To:  
NSW PLANNING PORTAL

**POWERHOUSE ULTIMO RENEWAL  
STATE SIGNIFICANT DEVELOPMENT APPLICATION  
SSD-32927319**

**SUBMISSION**

1 BUILDING ENVELOPE 3D VIEW 2 - FROM SW CORNER Scale

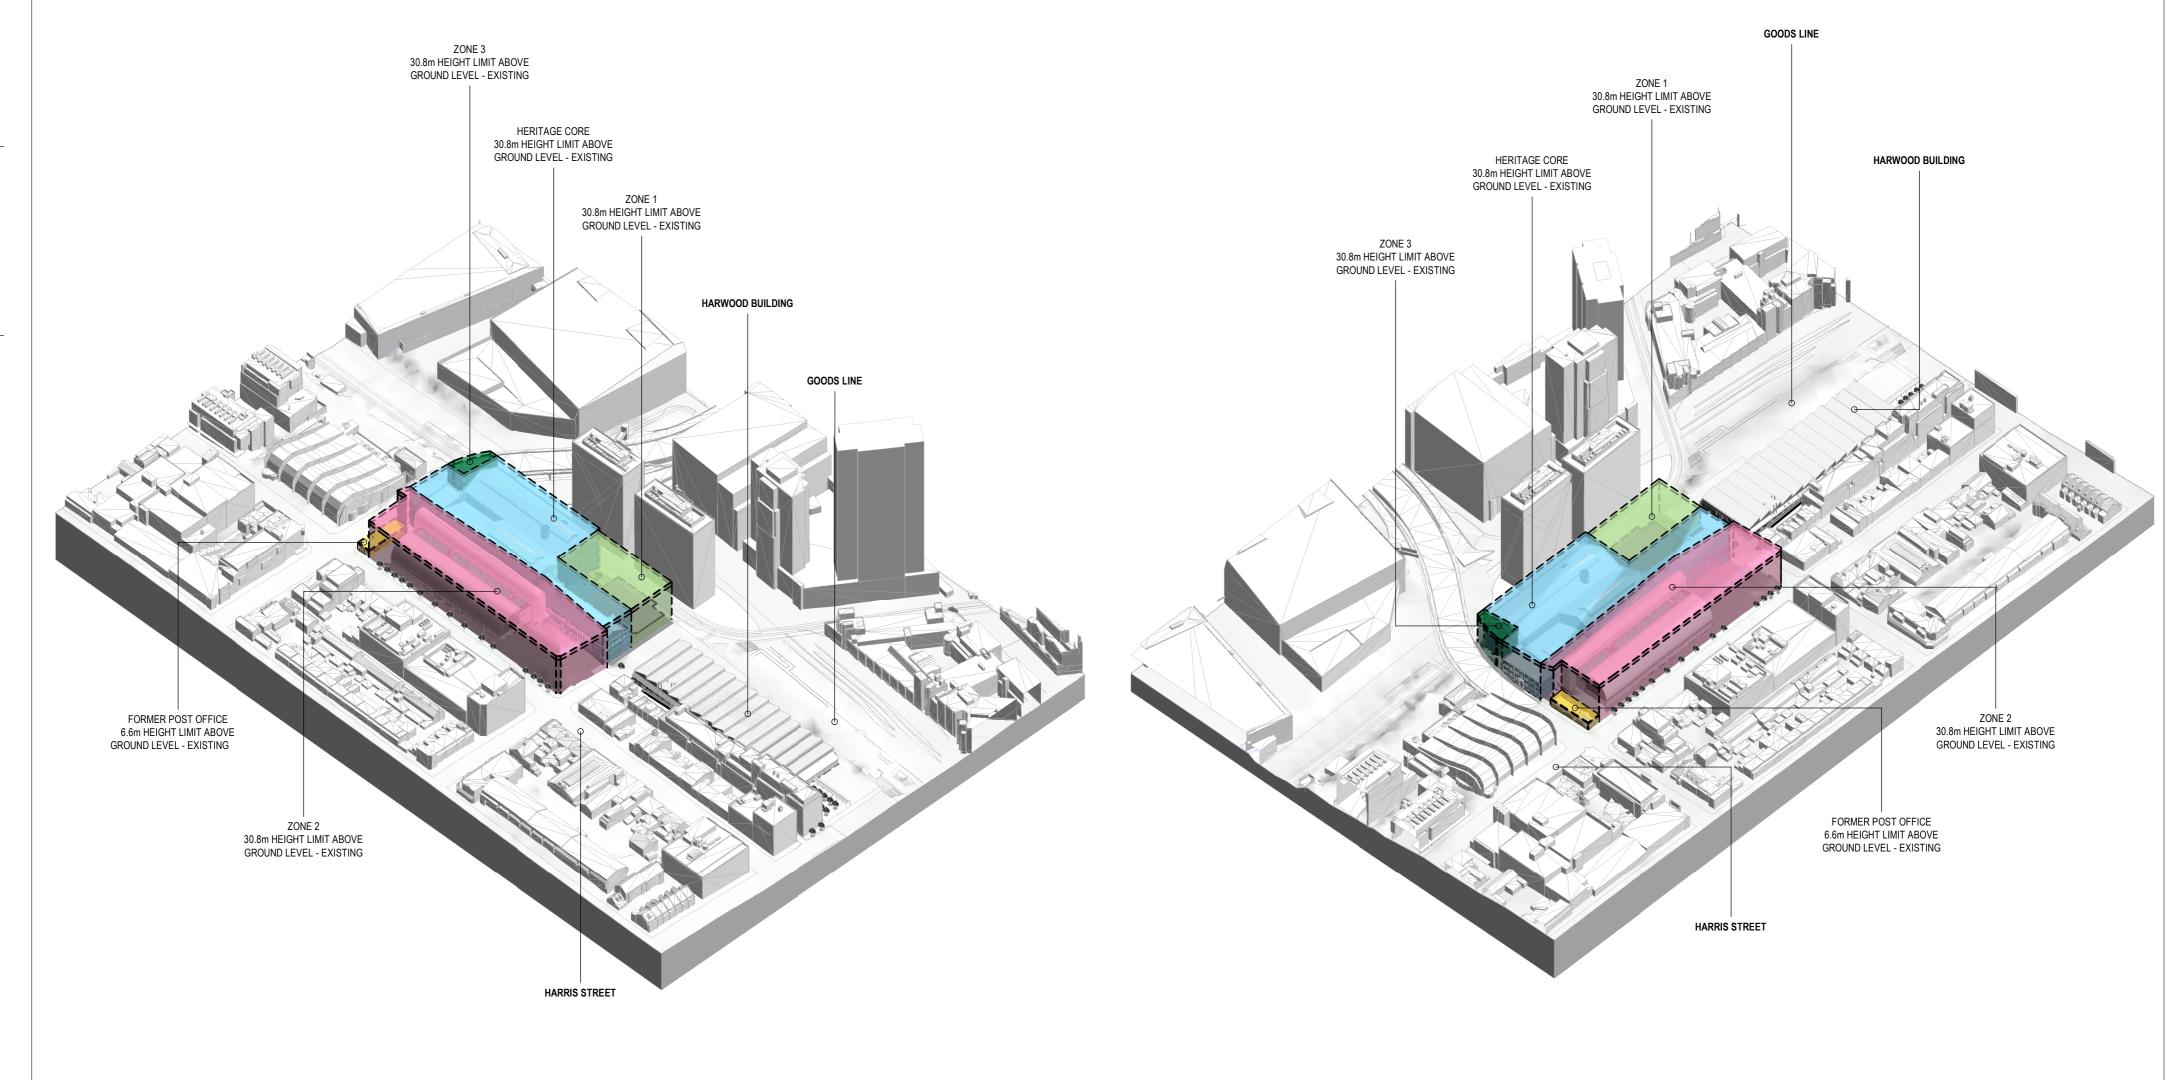
The Stage 1 (envelope) would authorise the chosen Architect to build a 25m building on the existing forecourt and to demolish the Wran Building and Galleria, replacing them with a 31m building.

The existing Harris St forecourt entrance would disappear.

This would result in new built forms dwarfing the heritage original Powerhouse buildings and the row of 3 storey buildings facing the Powerhouse across Harris St.

**NOTE:** The Sydney Local Environmental Plan LEP2012 (Height of Building - Sheet HOB\_008) lists the whole Powerhouse site (including the Harwood building) as T3 (28m). Hence a height of 31m is the maximum authorised for this site (28m+10% for design excellence).
